From: Laura Eastwood
Sent: 29 January 2021 15:07
To: Planning
Subject: FW: 3/2019/1104

Chris Dunderdale
Flood Risk Management Officer
Highways and Transport
Lancashire County Council

| Drawing Title HYDROBRAKE DETAILS S11 | | | | | |

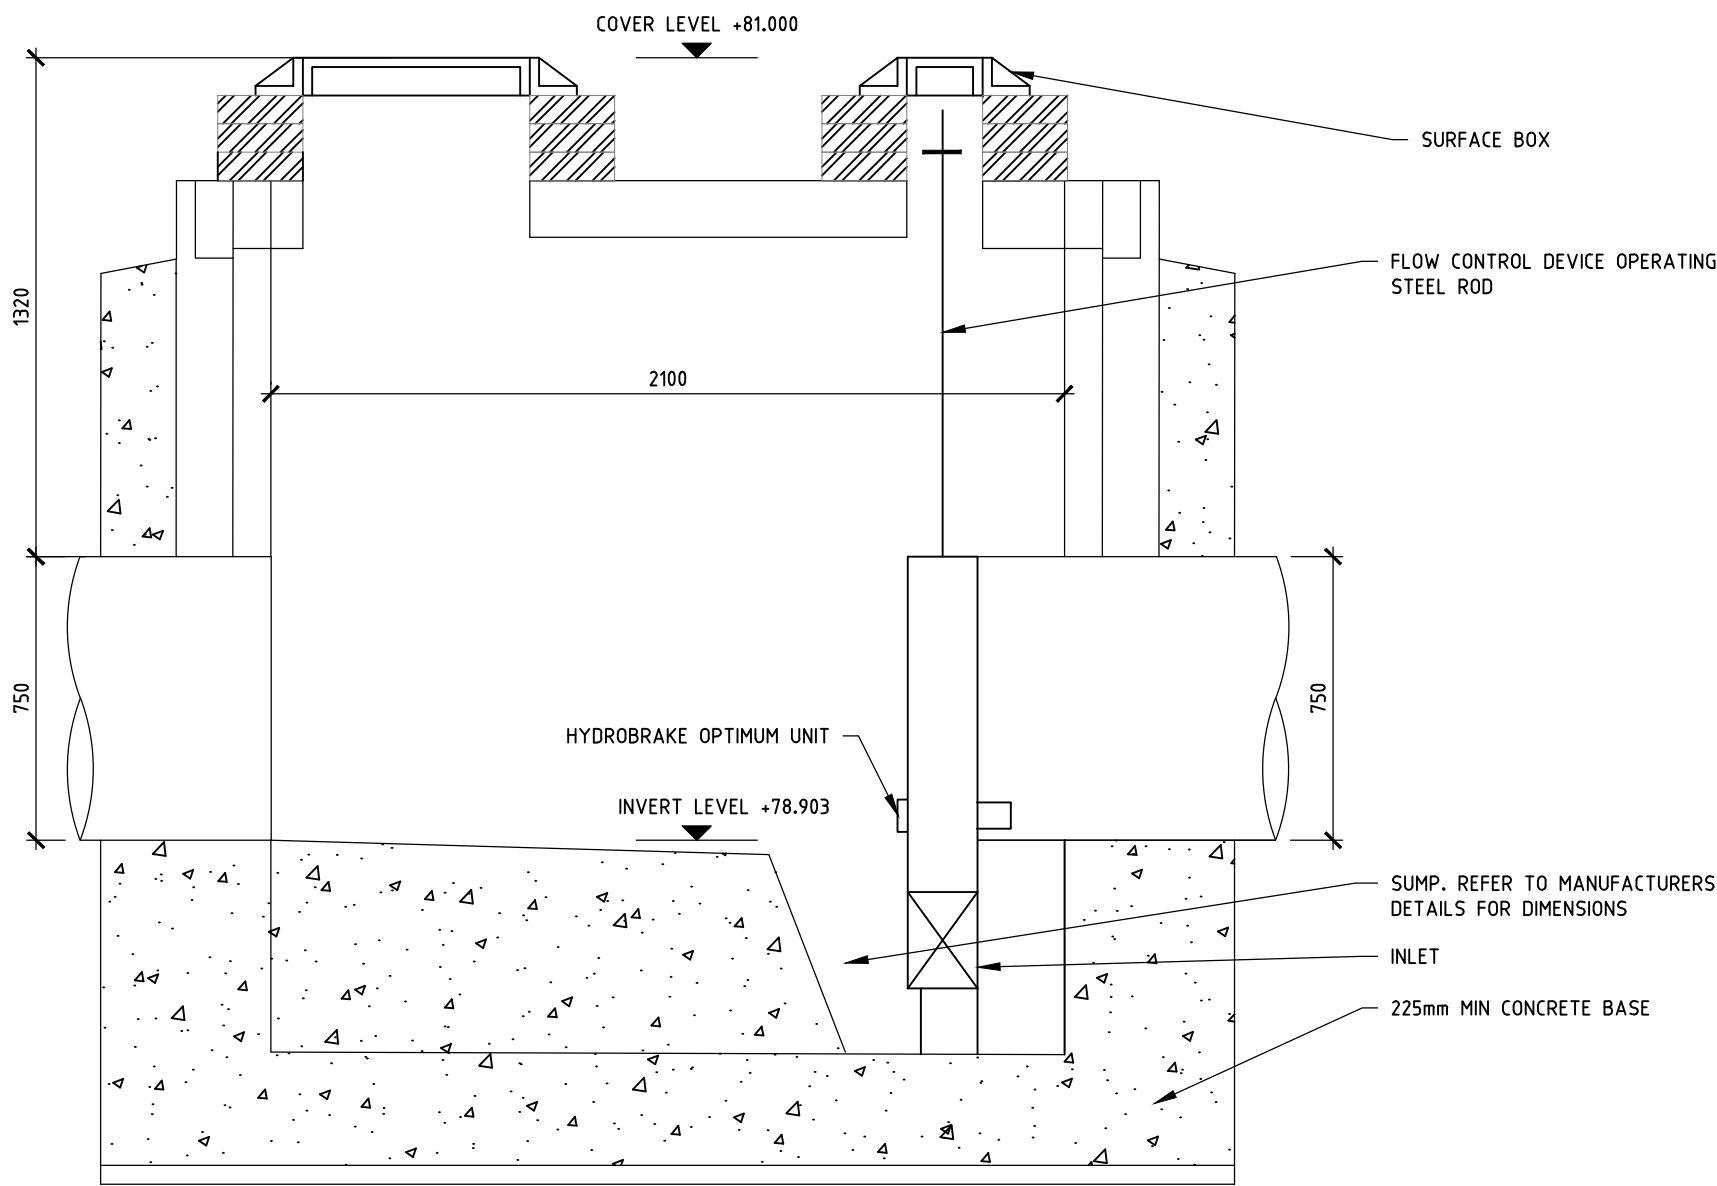
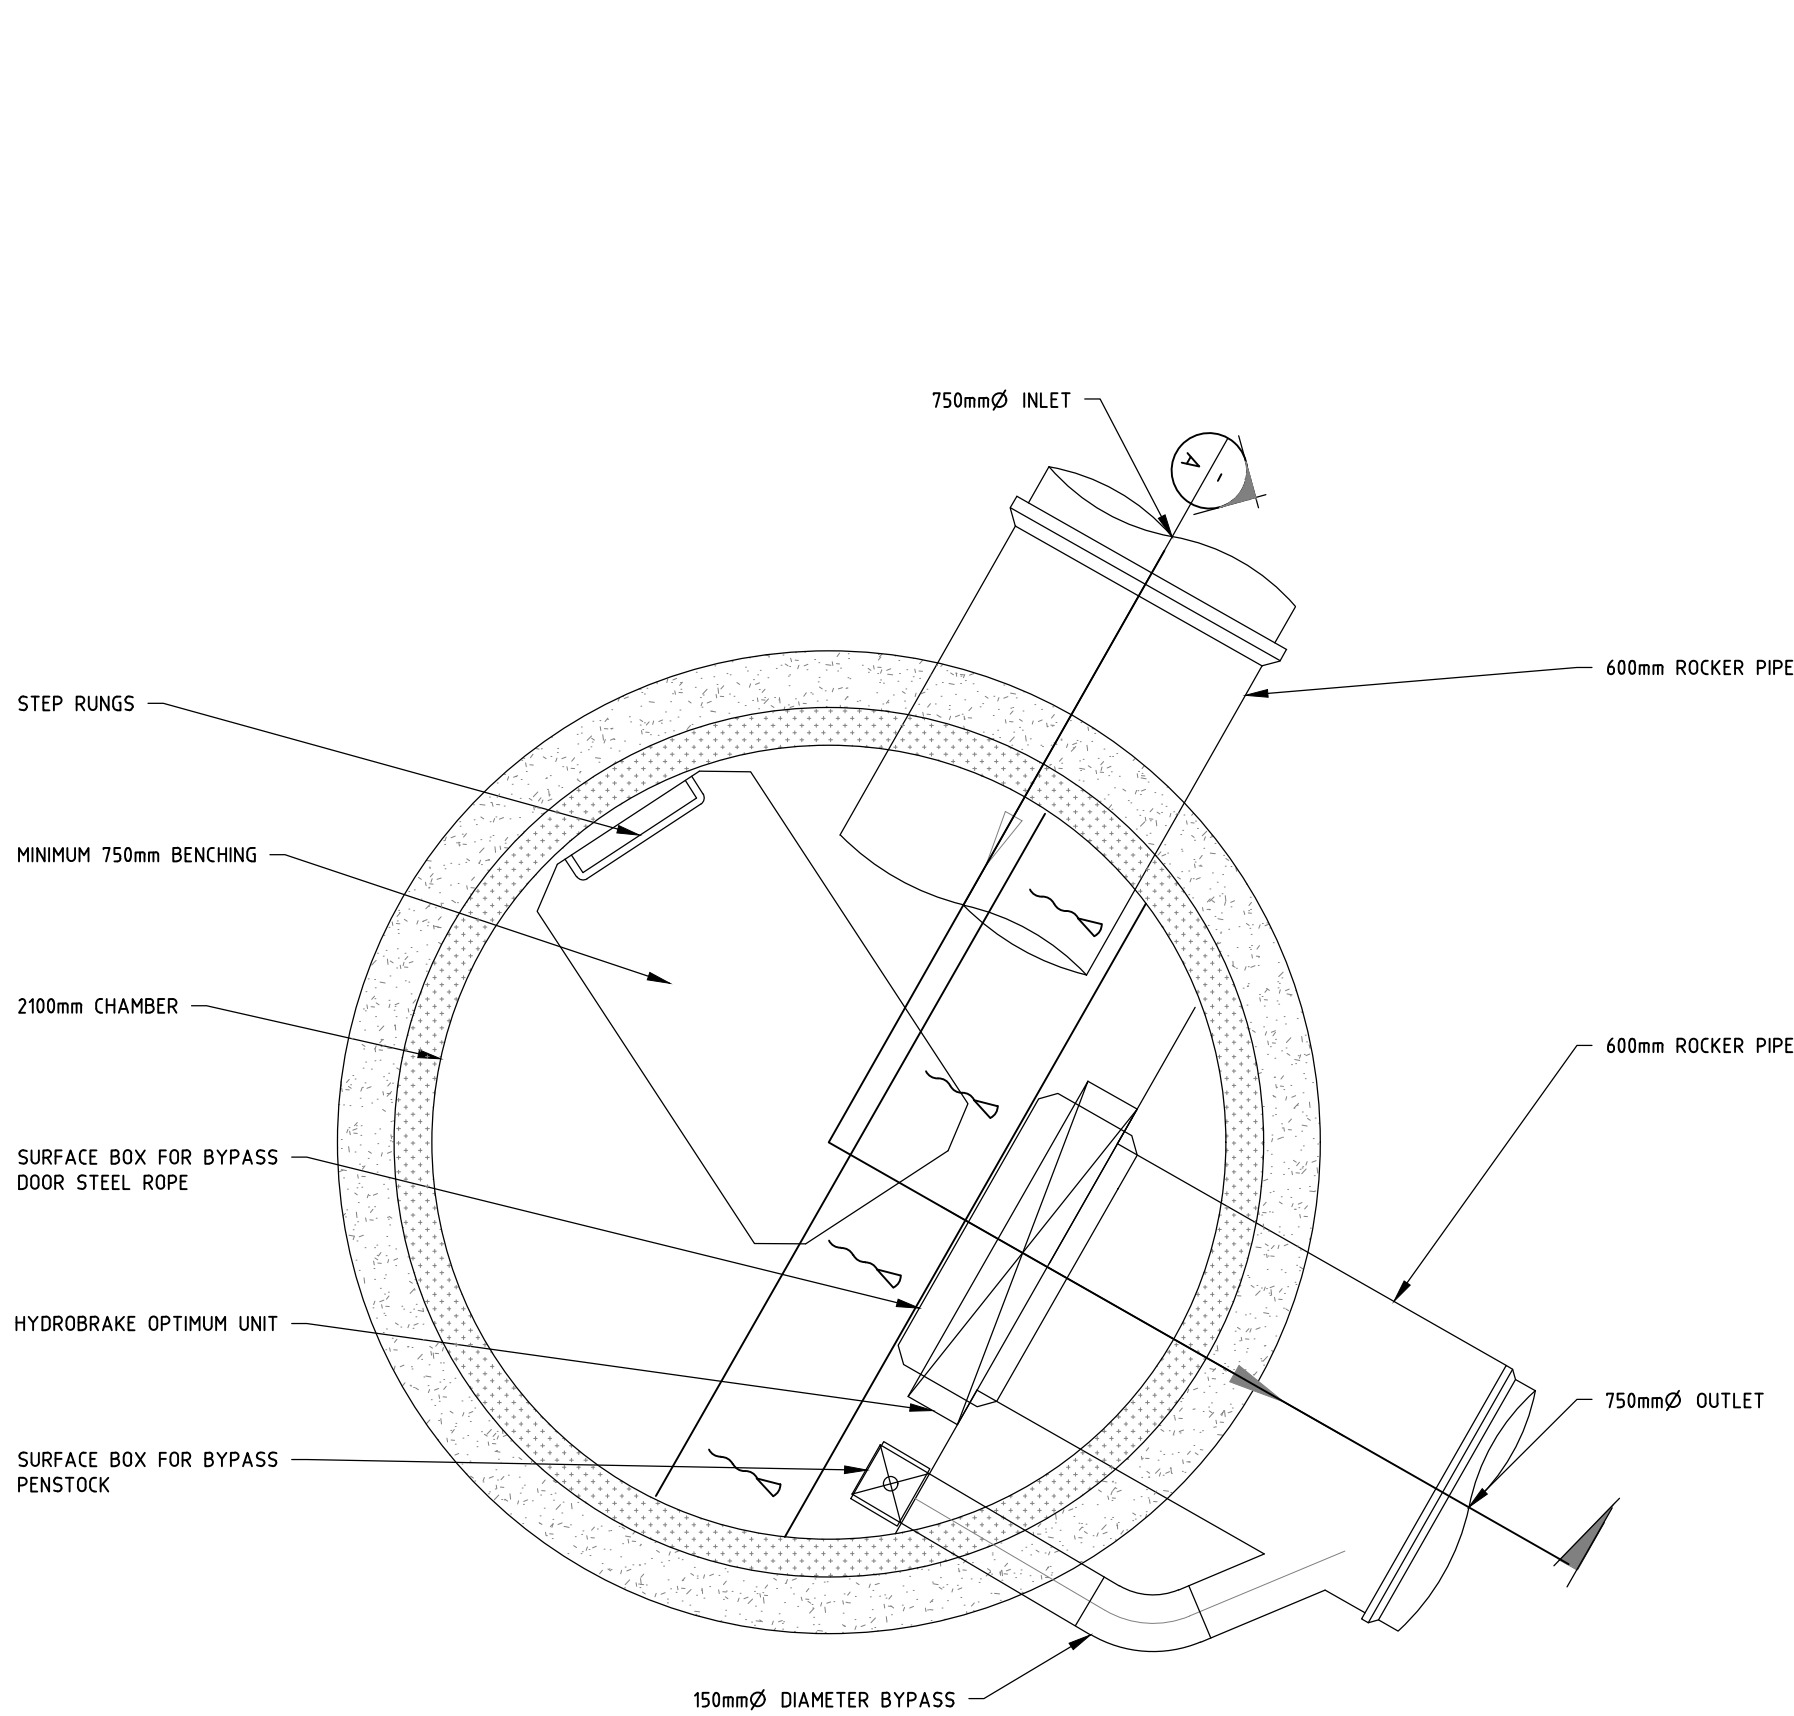
- I note the applicant's proposing to discharge surface water to the culverted watercourse at a maximum rate of 11.7l/s. However it's not clear at this stage whether that's runoff which physically enters the culvert now, or whether it's additional runoff that will enter the culvert on top of what's currently there now. If it's the latter, then the applicant will need to further investigate whether the culvert has sufficient capacity and is in a sufficient condition to accept the additional 11.7l/s from the site, without resulting in any increased risk of flooding on or off site. The applicant will also need to model their drainage network with a surcharged outfall to check that the system is able to discharge effectively should the culvert ever surcharge during flood conditions. Please can you bring these issues to the attention of the applicant and ask for further evidence to be provided in that regard?
